Fire Marshal Division

**Re: Cagle Furniture Carnival 2019
107 Carletta Cagle Drive
Spout Springs, NC 28326**

Application Number FMFW1903-0004

Cagle Furniture Spring CARNIVAL

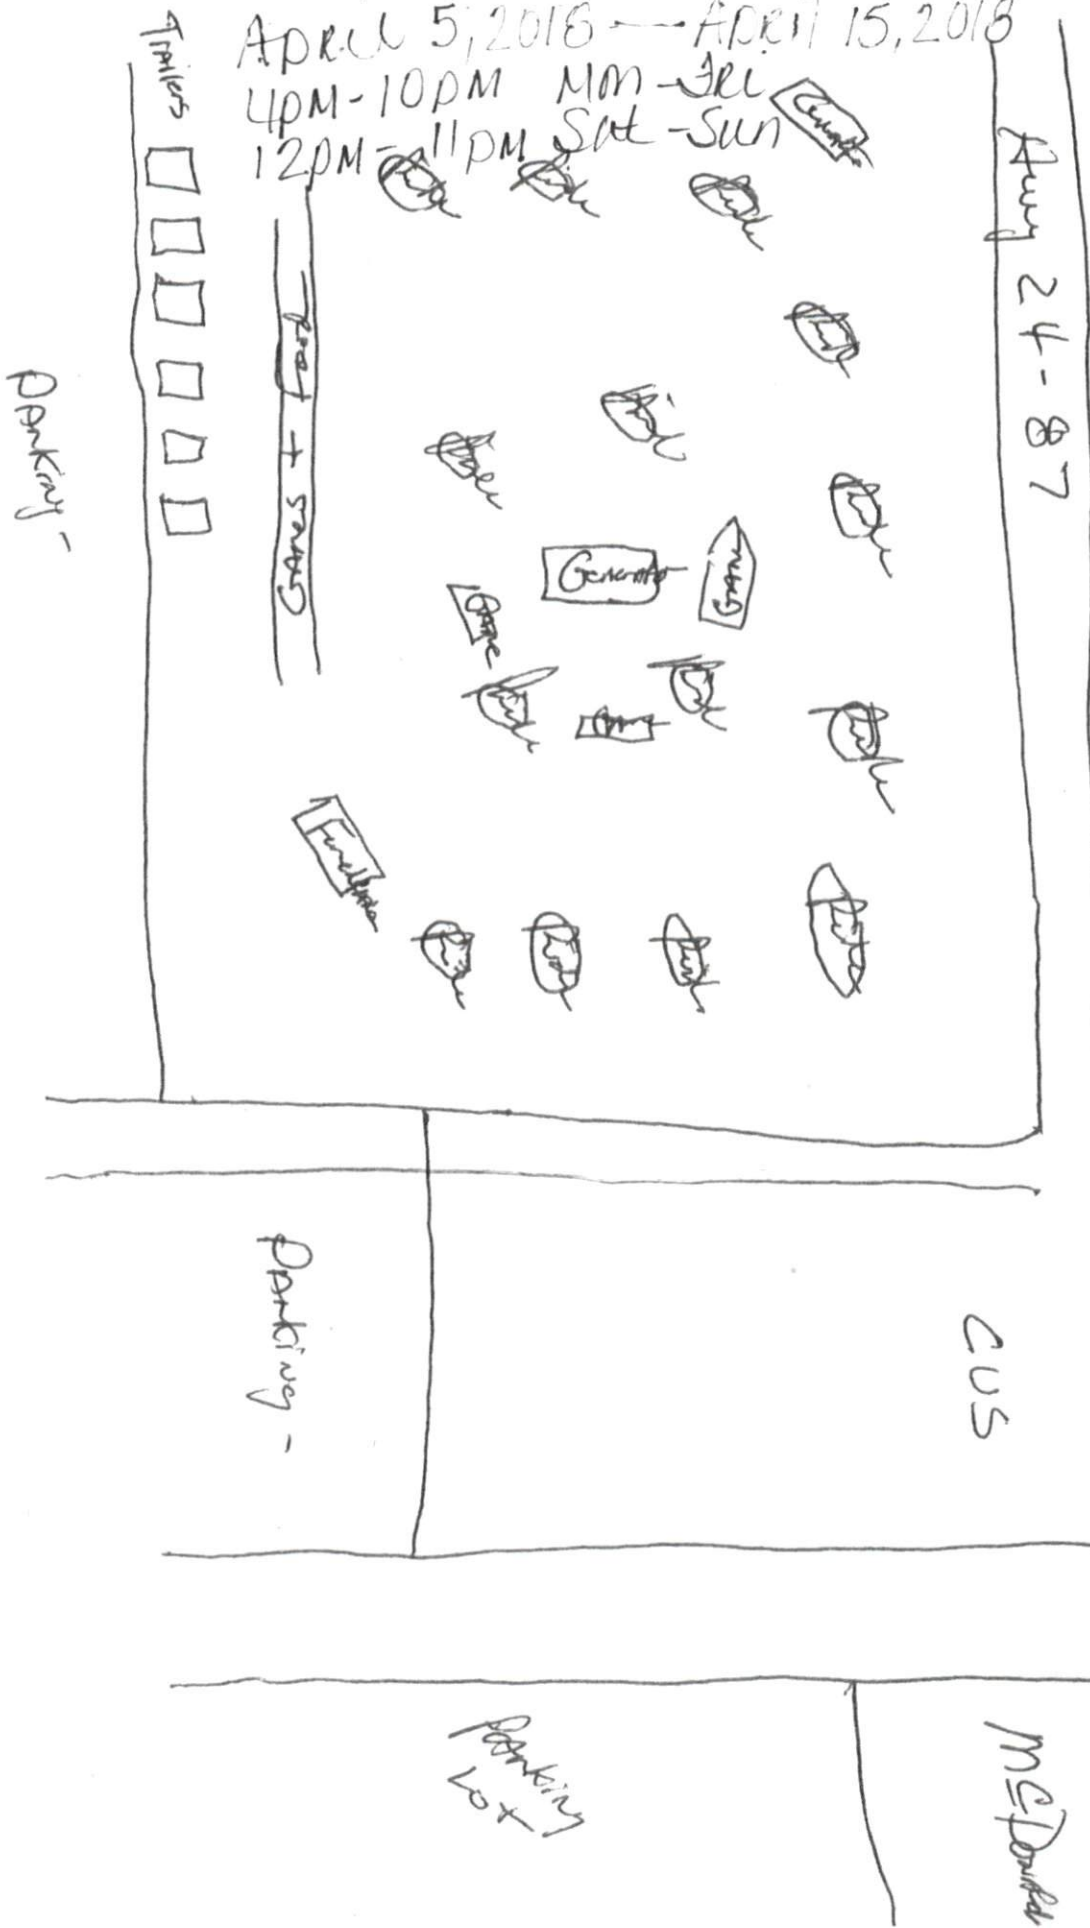
- Portable fire extinguishers shall be provided within a 30-foot (9144 mm) travel distance of commercial-type cooking equipment. Cooking equipment involving vegetable or animal oils and fats shall be protected by a Class K rated portable extinguisher.
- 2A-10B:C fire extinguisher shall be placed at tents/canopies with a travel distance not to exceed 100' from any fire extinguisher

- **2411.5 Cooking tents.**
 - Tents where cooking is performed shall be separated from other tents, air-supported, air-inflated or tensioned membrane structures, temporary membrane structures or canopies by a minimum of 20 feet (6096 mm).

- **2411.6 Outdoor cooking.**
 - Outdoor cooking that produces sparks or grease-laden vapors shall not be performed within 20 feet (6096mm) from a tent, air-supported, air-inflated or tensioned membrane structure, temporary membrane structure or canopy.

- **2415 Generators**
 - Generators and other internal combustion power sources shall be separated from tents, air-supported, air-inflated or tensioned membrane structures, temporary membrane structures or canopies by a minimum of 20 feet (6096 mm) and shall be isolated from contact with the public by fencing, enclosure or other approved means.
